CITY OF ALBUQUERQUE
MUNICIPAL DEVELOPMENT DEPARTMENT
ENGINEERING DIVISION/DESIGN HYDROLOGY SECTION

Re: Drainage Plan for Anthony,s (Menaul and Hiawatha)

REF: ANTHONY'S (H22/D51) RECEIVED JULY 23, 1985

REF: REVISED DRAINAGE PLAN FOR ANTHONY'S (H22-D51) RECEIVED JULY 31, 1985

# GRADING & DRAINAGE PLAN FOR

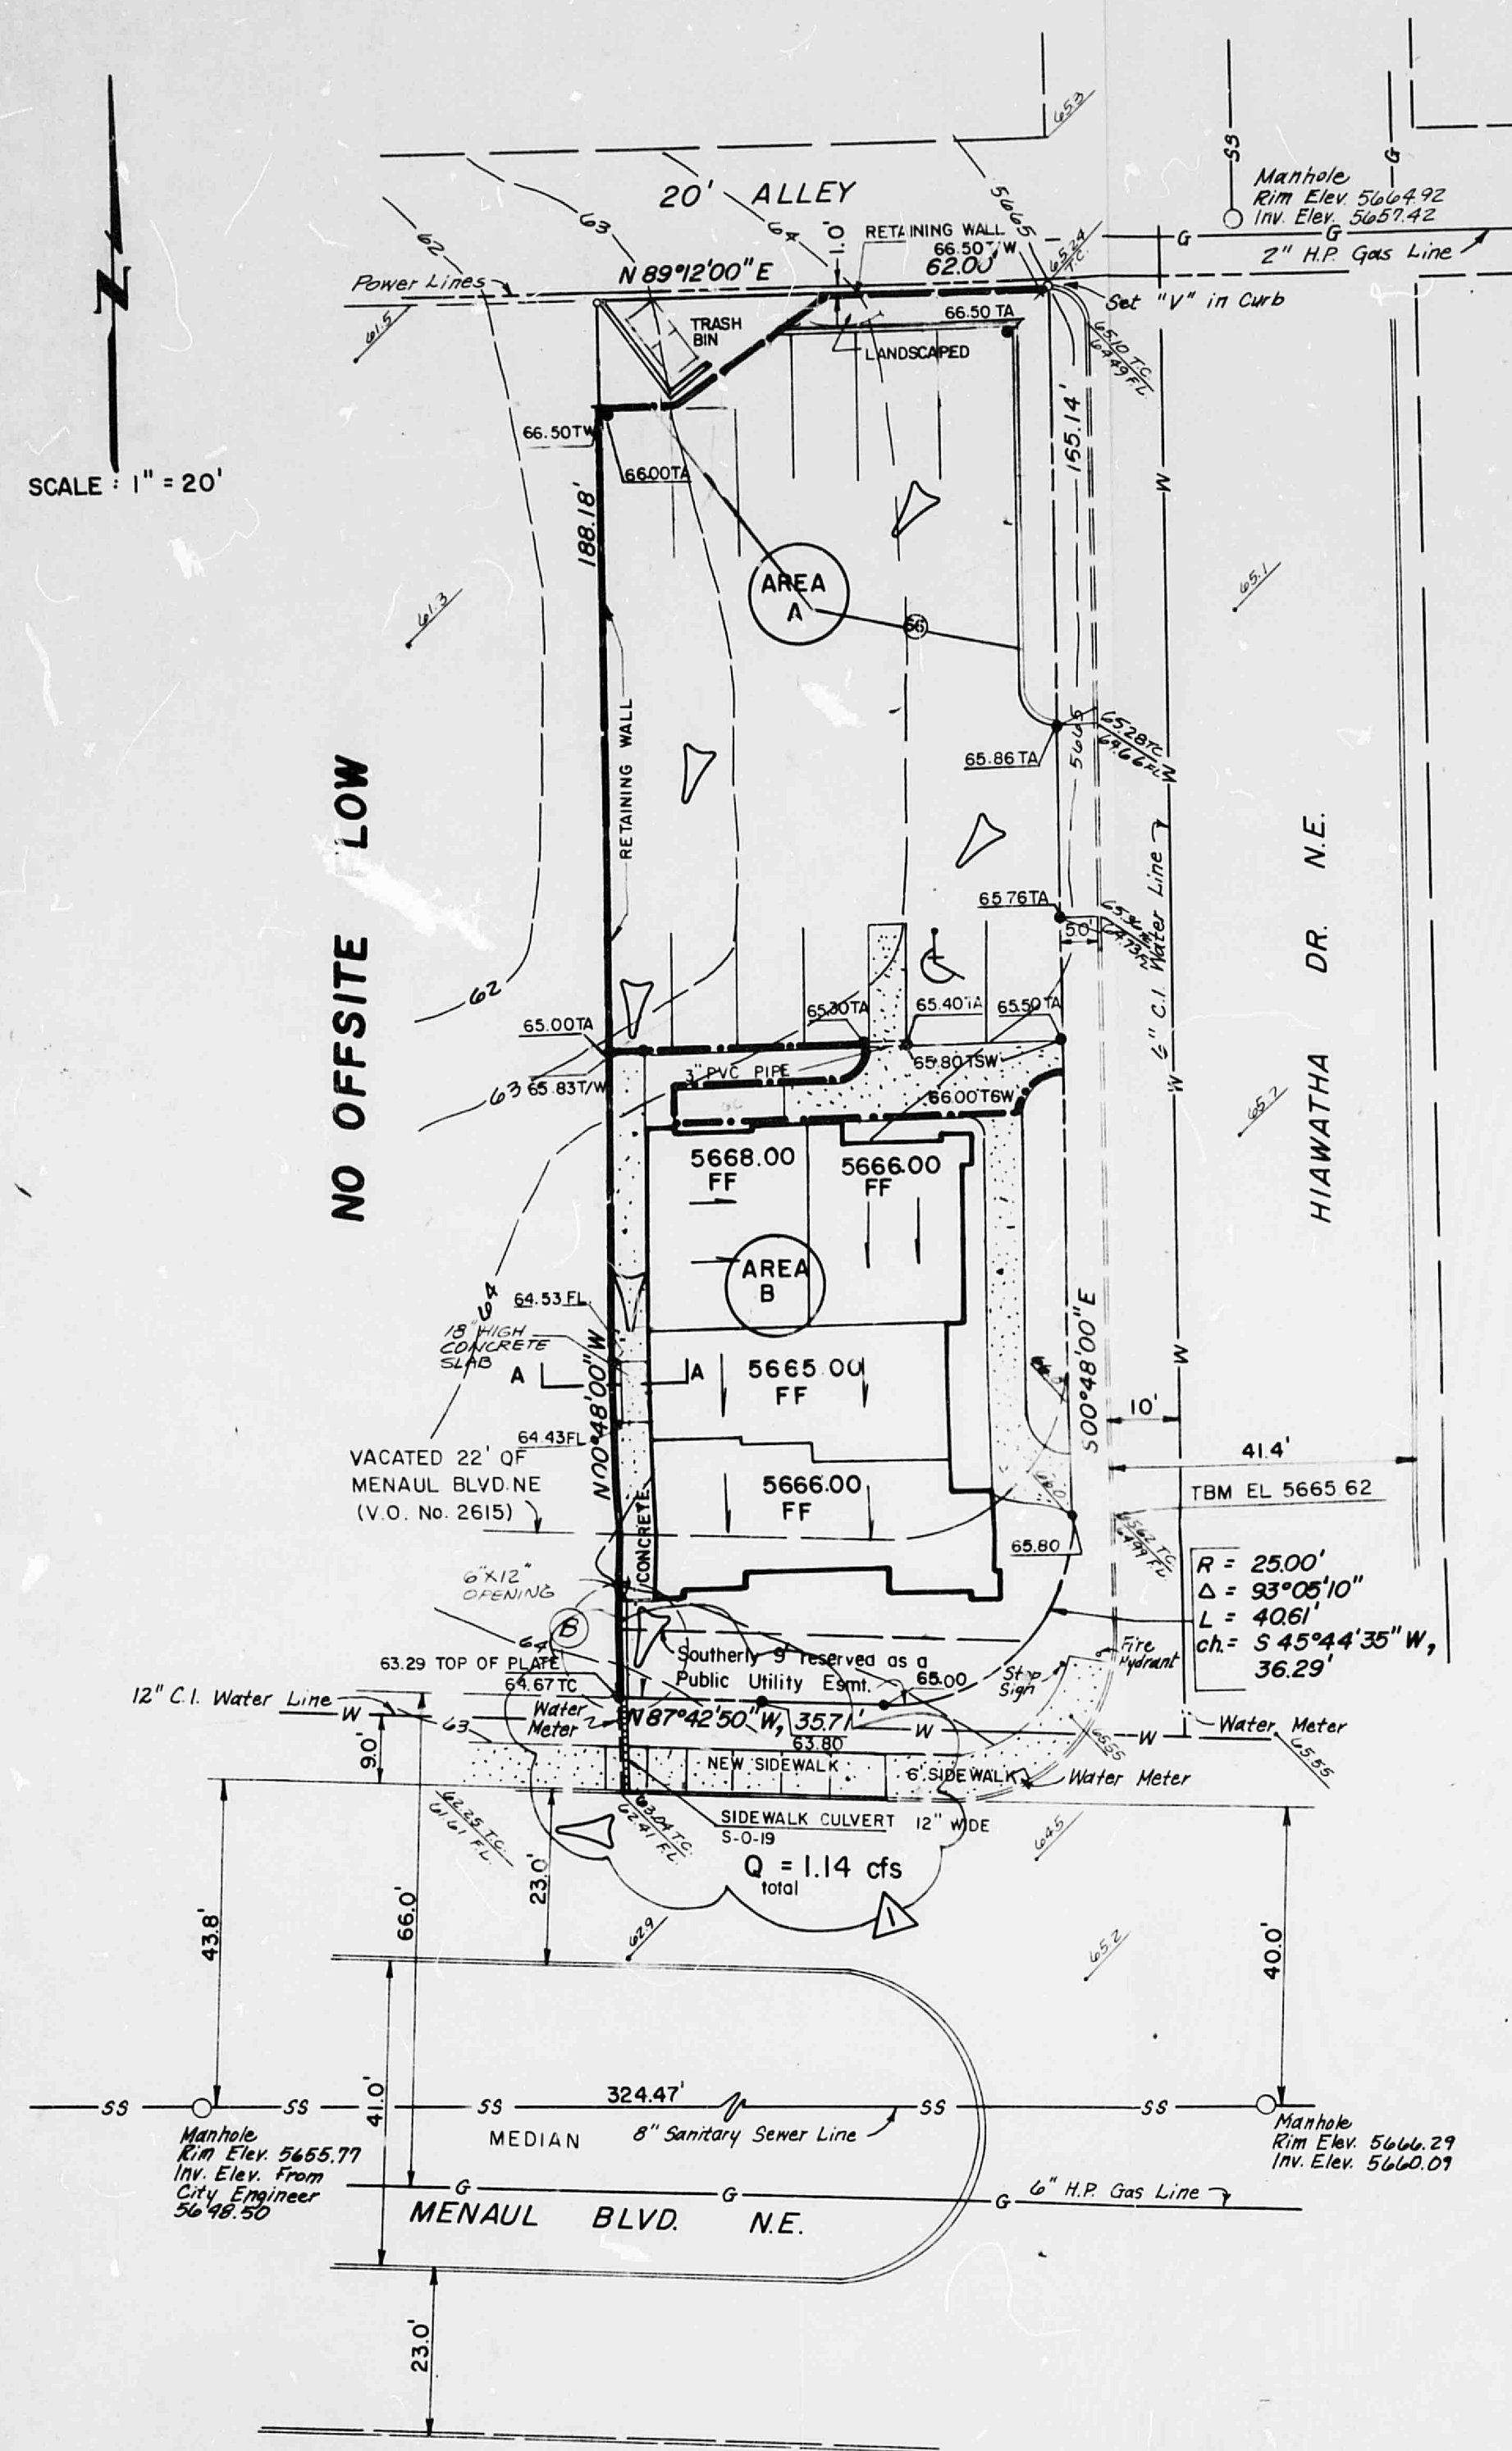
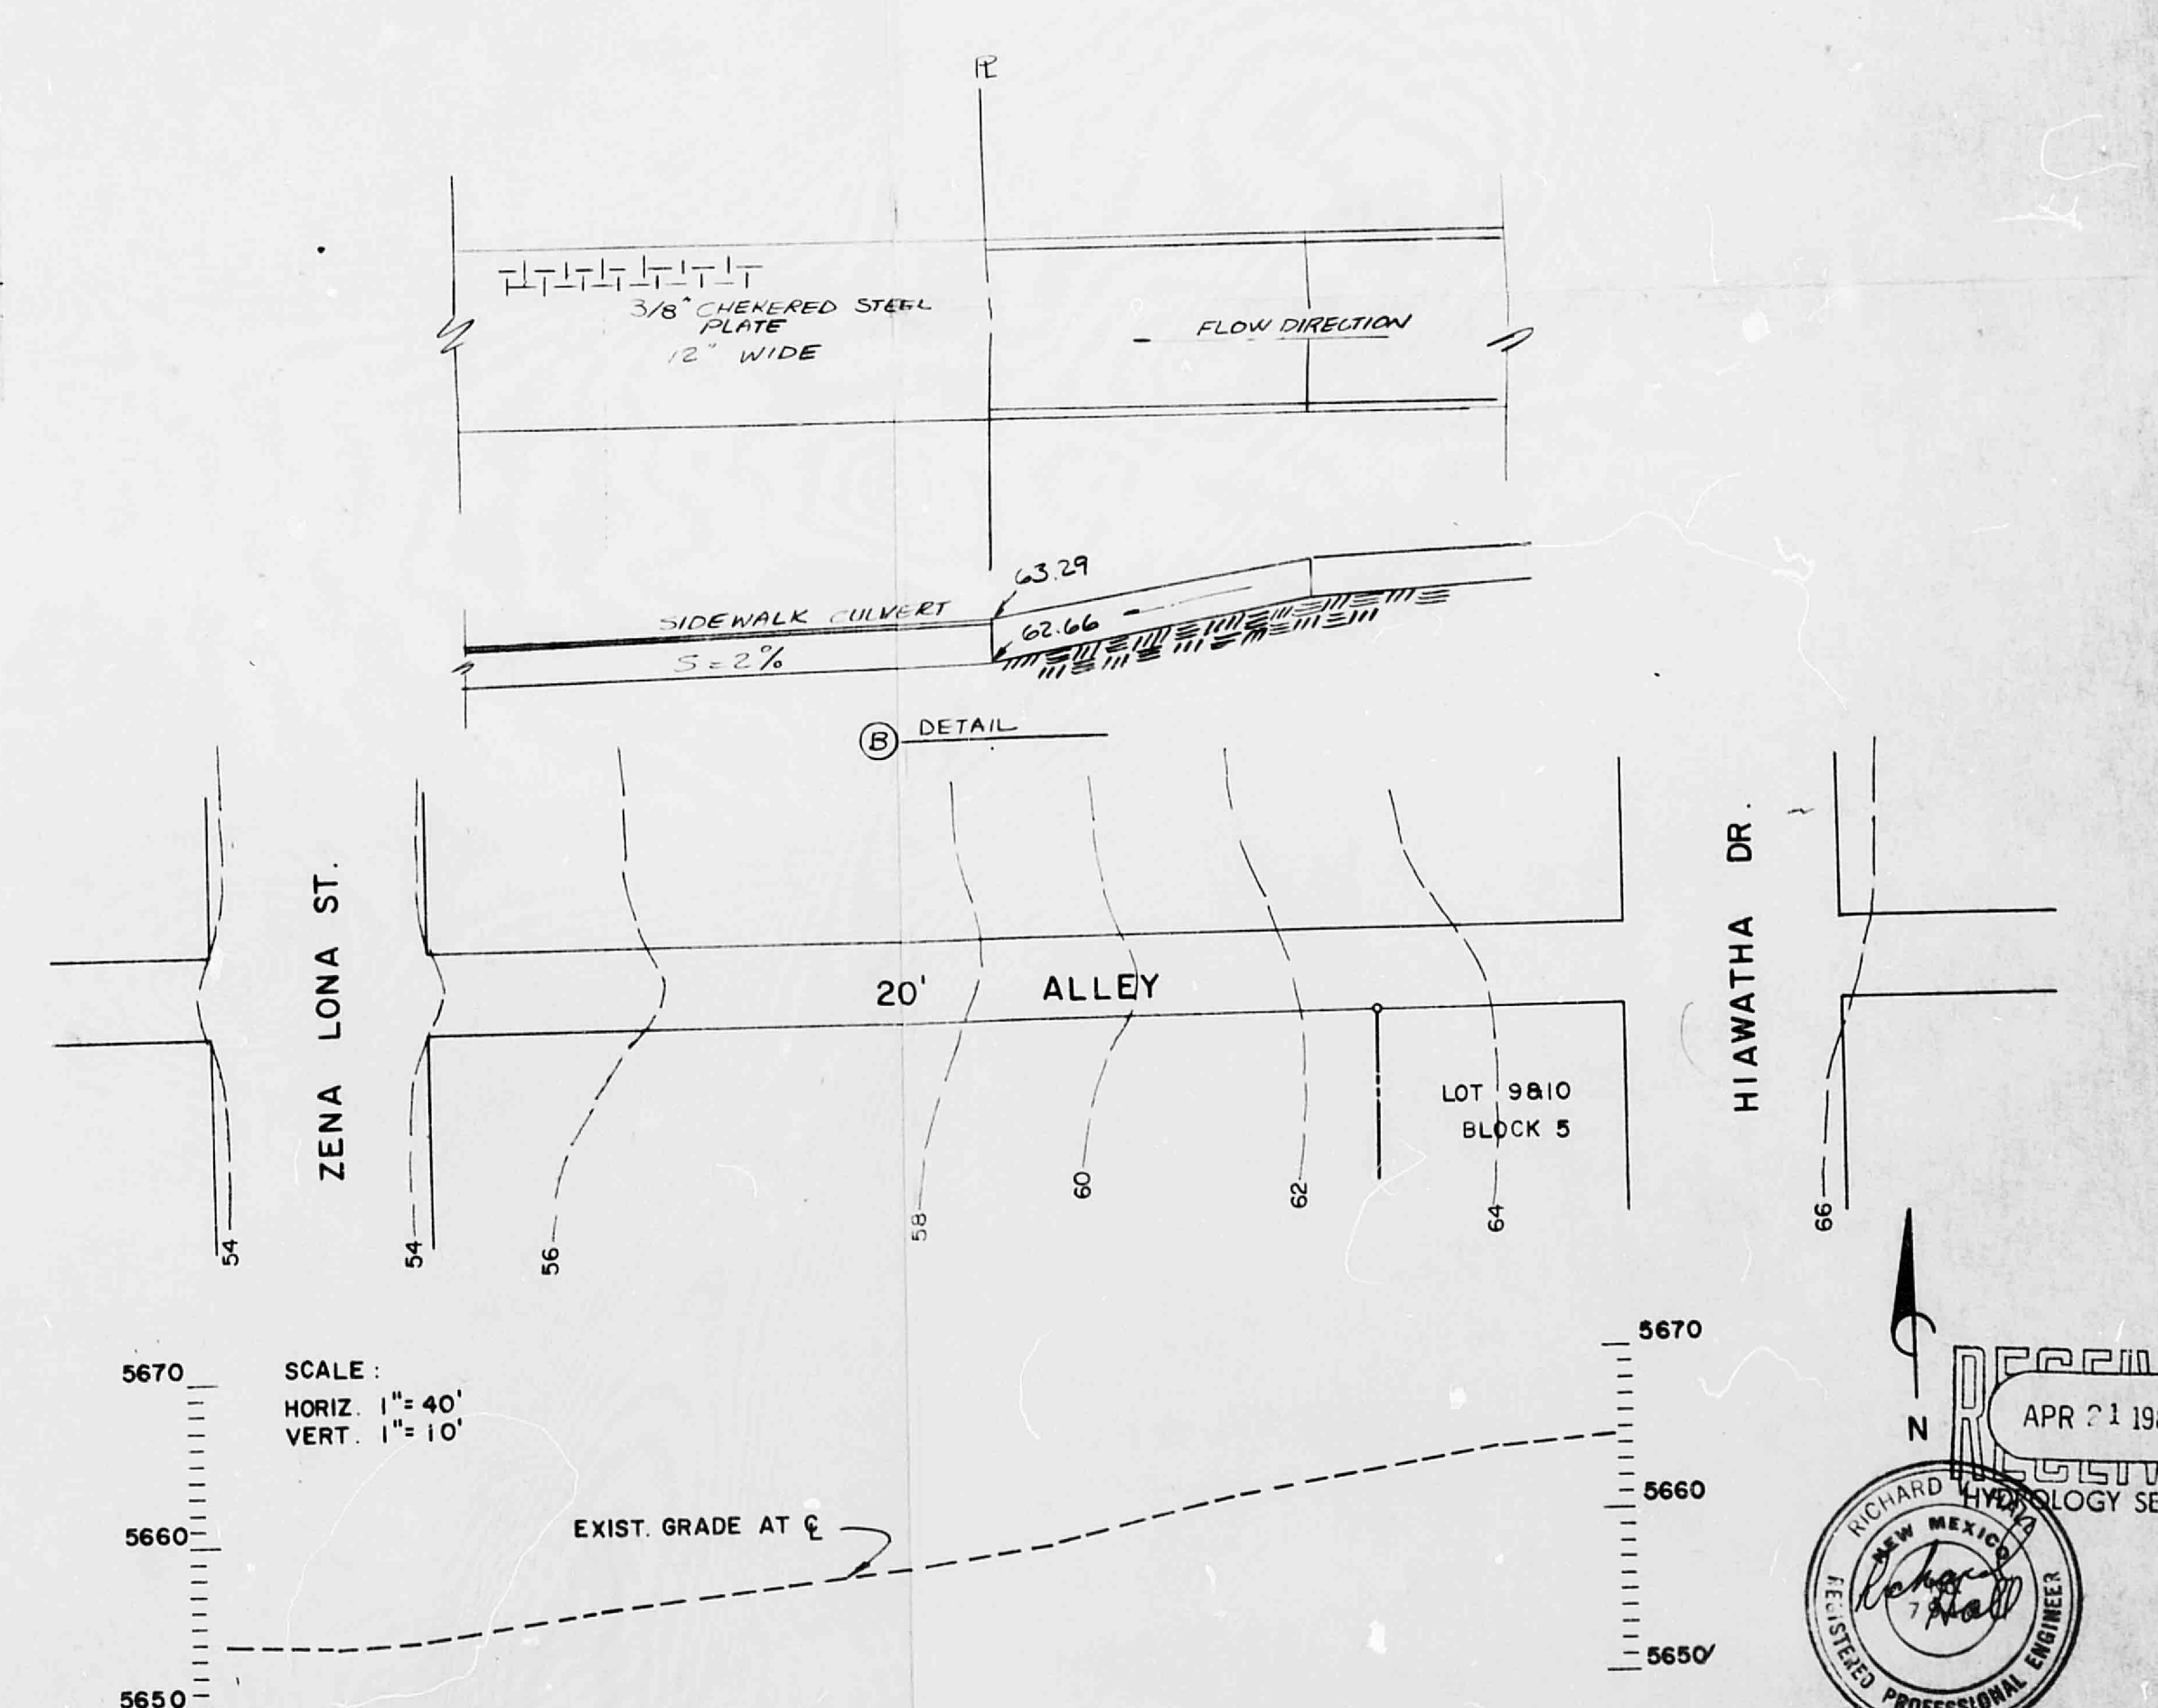
Since insufficient information has been provided for analysis of the capacity of the alley, improvements to the alley will be required. The alley way is being utilized as an outfall for more than 50 percent of the site and therefore the alley will be required to be improved all the way from Hiawatha Drive to Zena Lona Street.

Please proceed with the appropriate plans and process for making these improvements. Until such time as the Work Order for these improvements is released, the drainage plan cannot be approved for Building Permit purposes. The site is dependent on the alley for an outfall.

1. New information sheet with resubmittal designation.
2. Engineer's stamp with revision date and signature.
3. Please include calculations using the weir equation or some other appropriate equation to evaluate the culvert capacity.
4. Signed-off copy of the S.O. #19 must be submitted to our office before Hydrology will release the Certificate of Occupancy.

1. Using Mannings Equation you cannot evaluate the entry conditions. Therefore, the rectangular weir equation may be appropriate in this case. Please recompute to check for capacity.
2. Signed-off copy of the "Drainage Facilities within City Right-of-Way" document signed by the inspector and his supervisor.

- 1. The site has been regraded in order to drain
the water into Menaul Blvd. via existing drive pad,
instead of 20' alley.*
- 2. A copy of recorded plat for vacating lot line
is also provided.*
